Ribble Valley Borough Council
Housing & Development Control

Application no: **3/2021/1271**

Address: **Pinfold Farm Preston Road Ribchester PR3 3YD**

Proposal: **Proposed demolition of agricultural buildings, erection of a detached dwelling and garage.**

Proposed Site Plan
Scale (1:200)

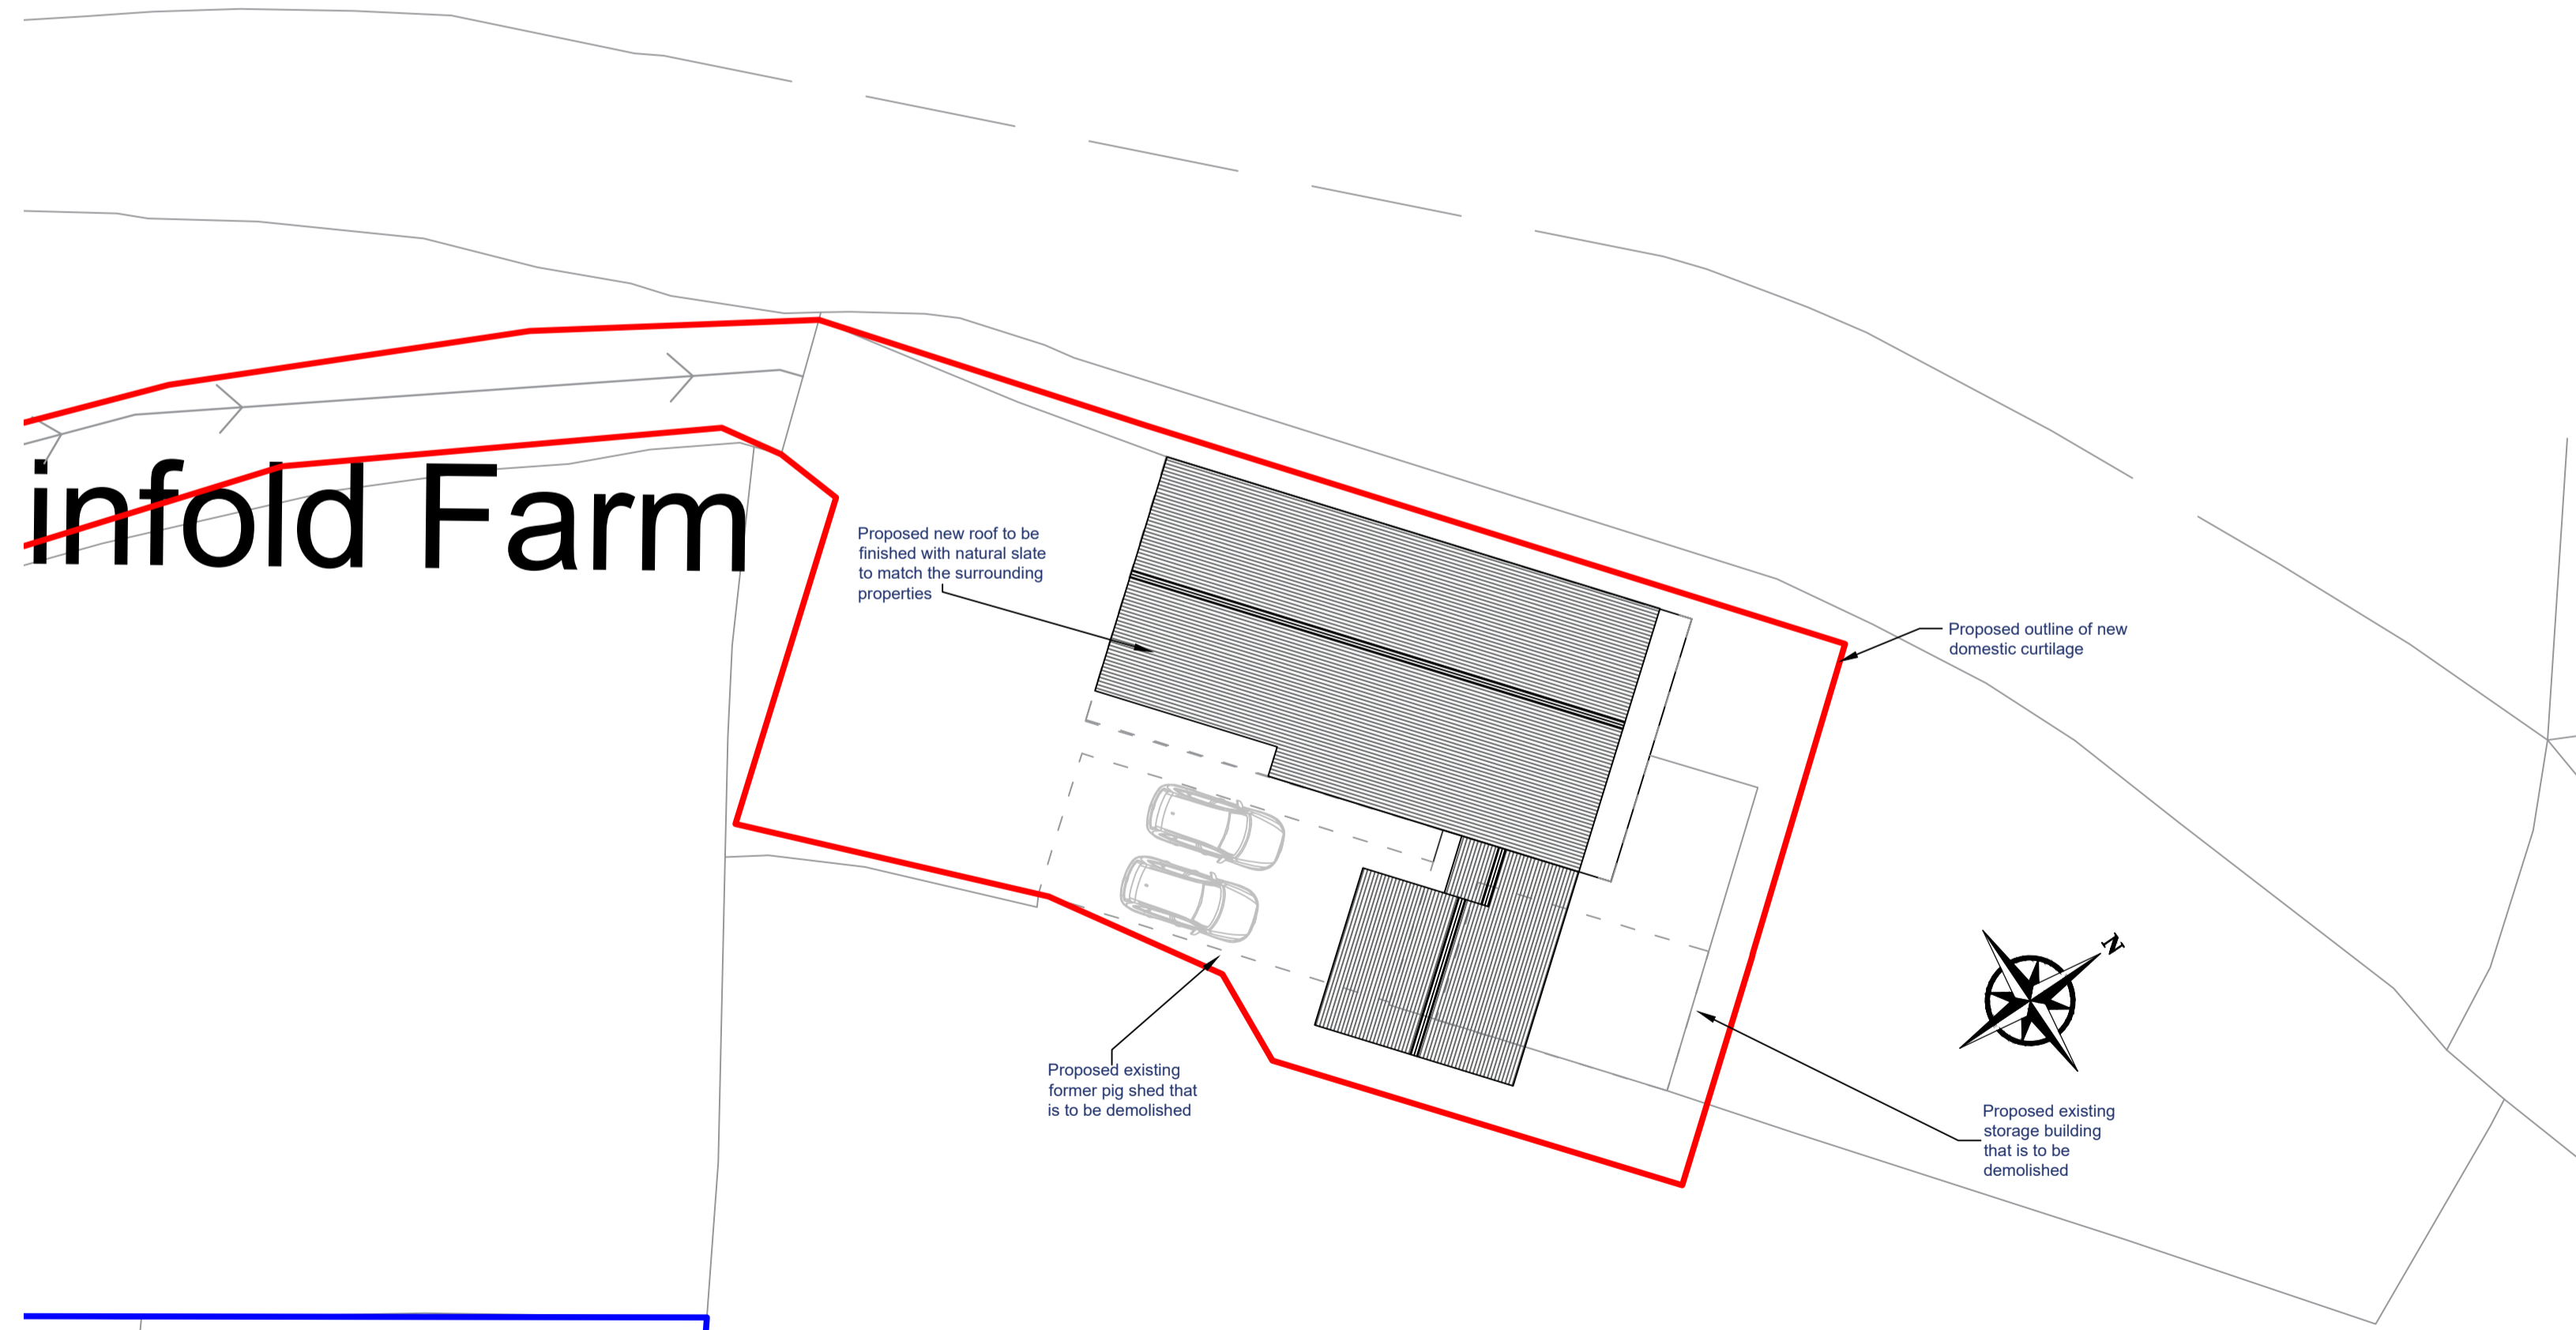
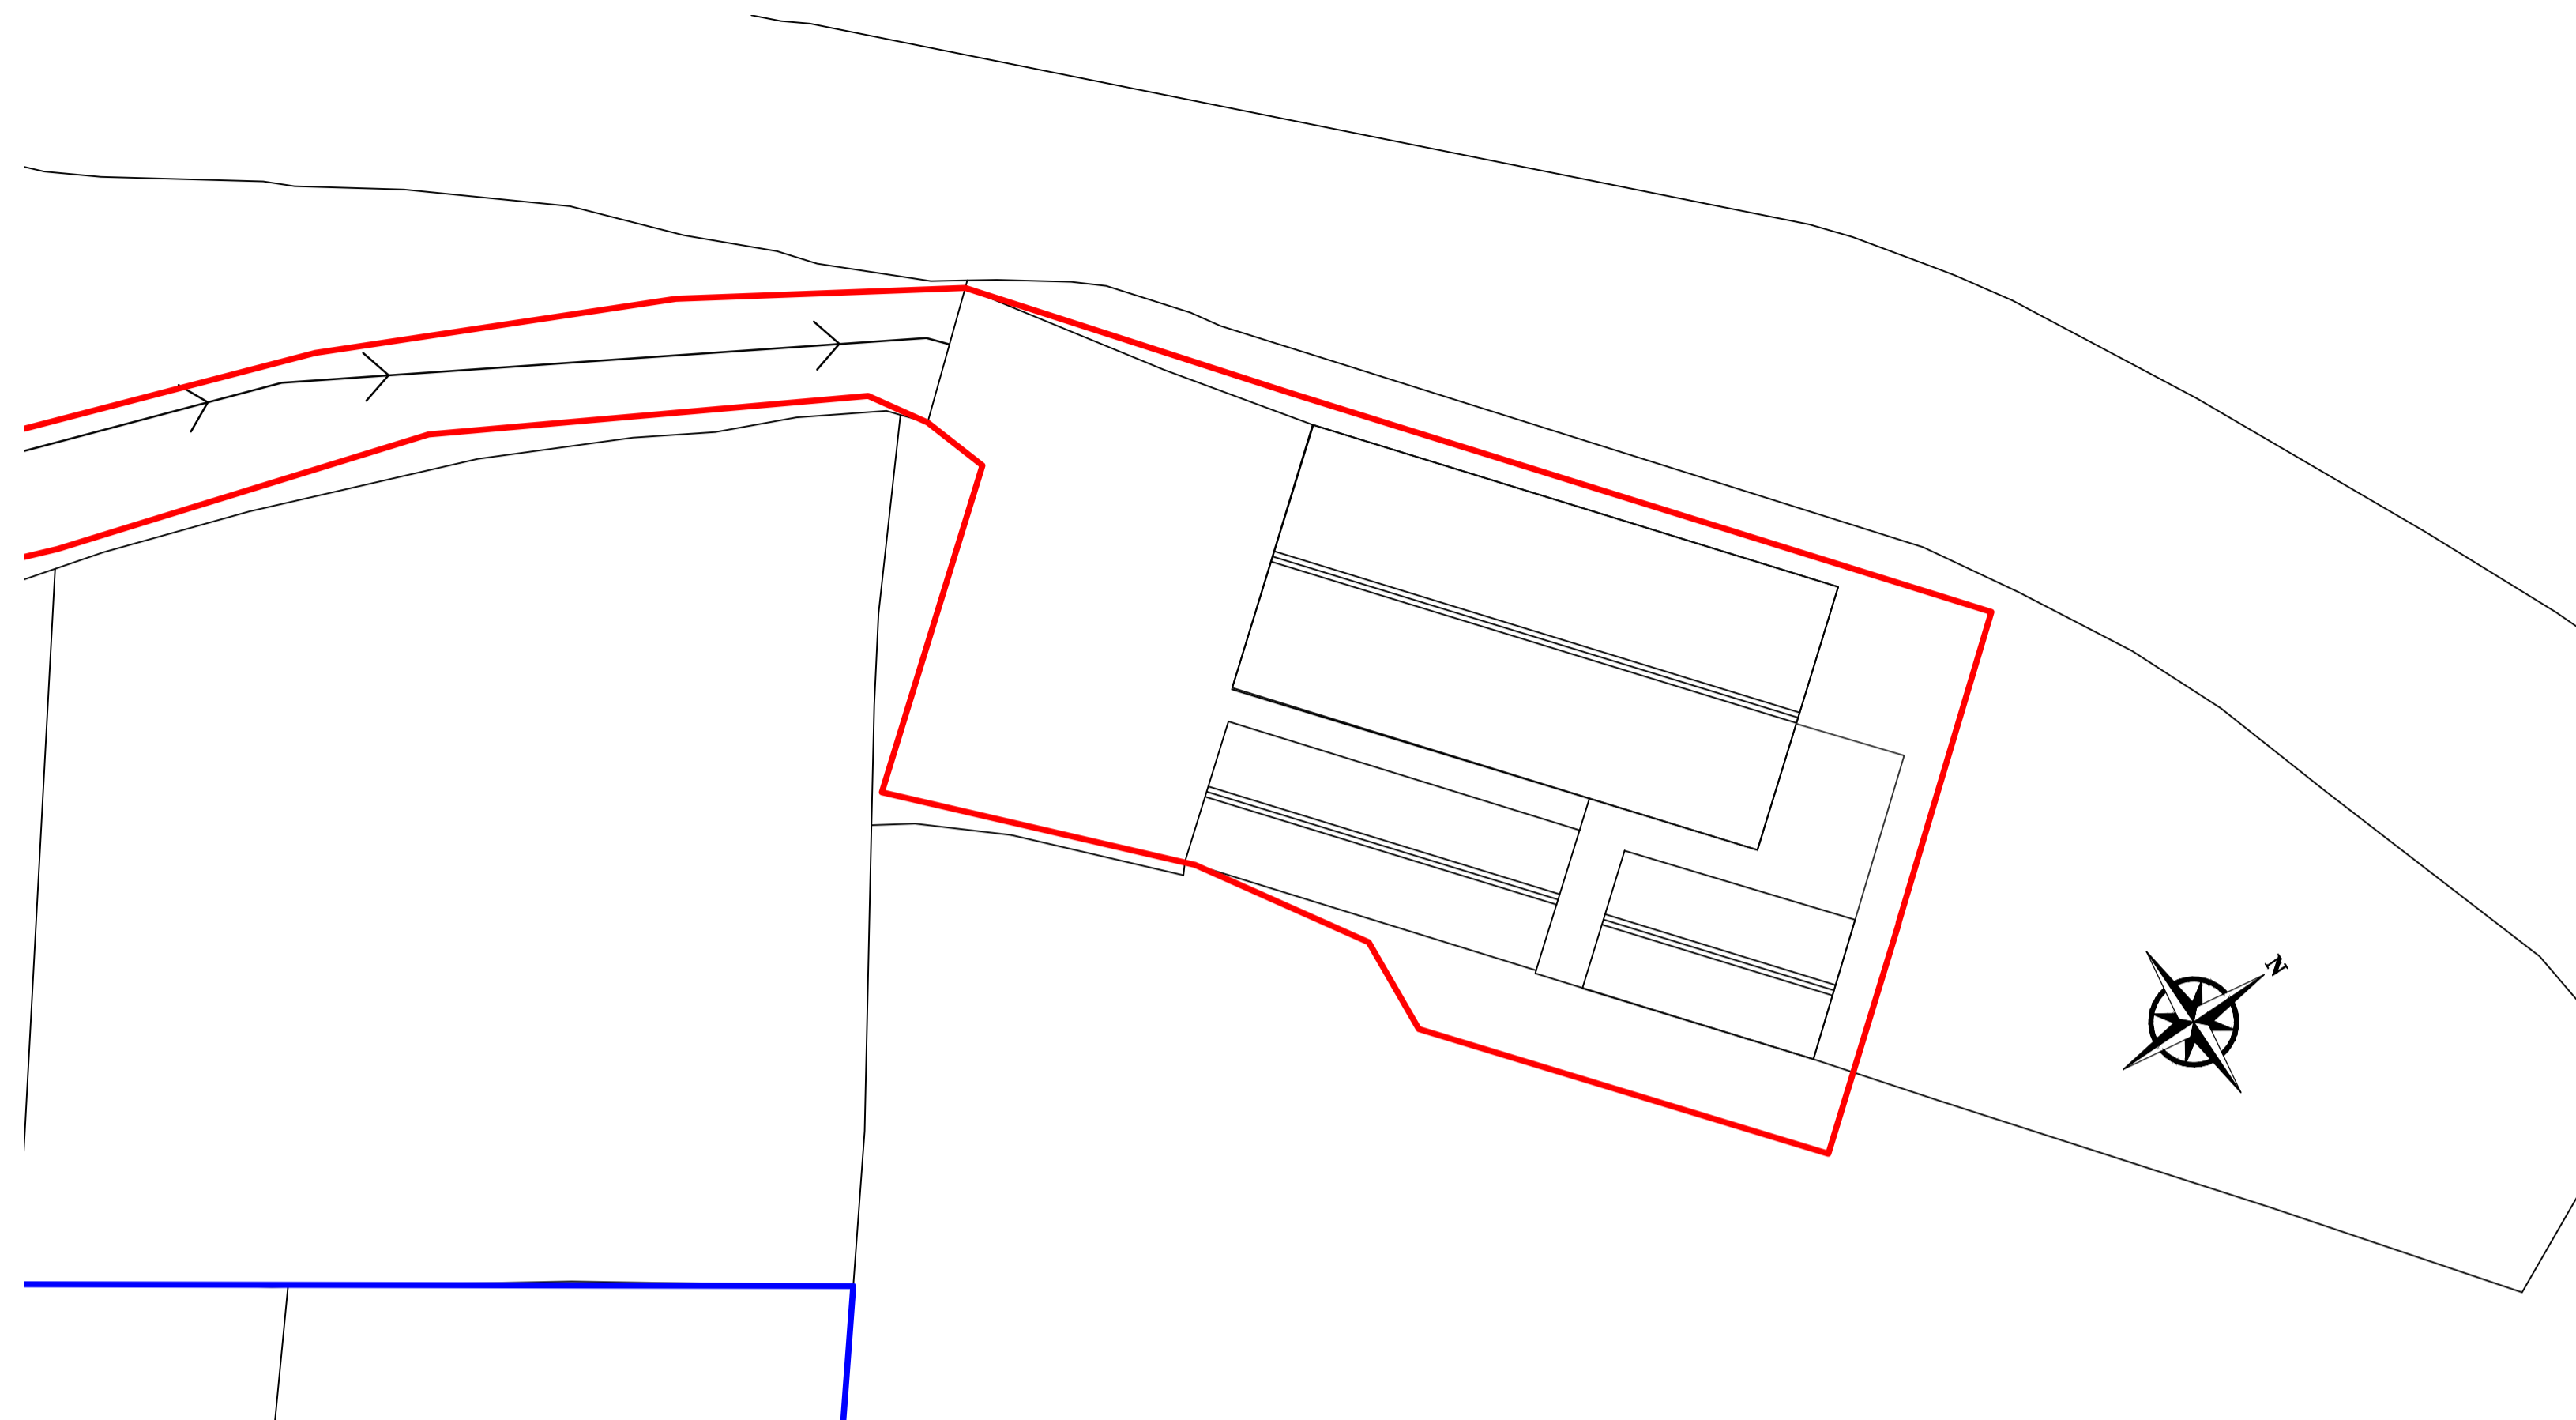
The LHA have reviewed Holden drawing number 002 Rev B titled "Site Plans" and are aware that the access to the proposal has already been approved by the LHA under application reference 3/2020/0855, which was for the same scheme at the site. Therefore, given the access remains unaltered and the proposal will not fully intensify the use of the access, the LHA have no objection to the proposal.

The LHA have reviewed Holden drawing number 002 Rev B titled "Site Plans" and are satisfied that the parking arrangements comply with the LHAs parking guidance found in the Joint Lancashire Structure Plan. Therefore, the LHA have no further comments to make.

1. The development hereby permitted shall not be occupied until such time as the parking and turning facilities have been implemented in accordance with Holden drawing number 002 Rev B. Thereafter the onsite parking provision shall be so maintained in perpetuity.
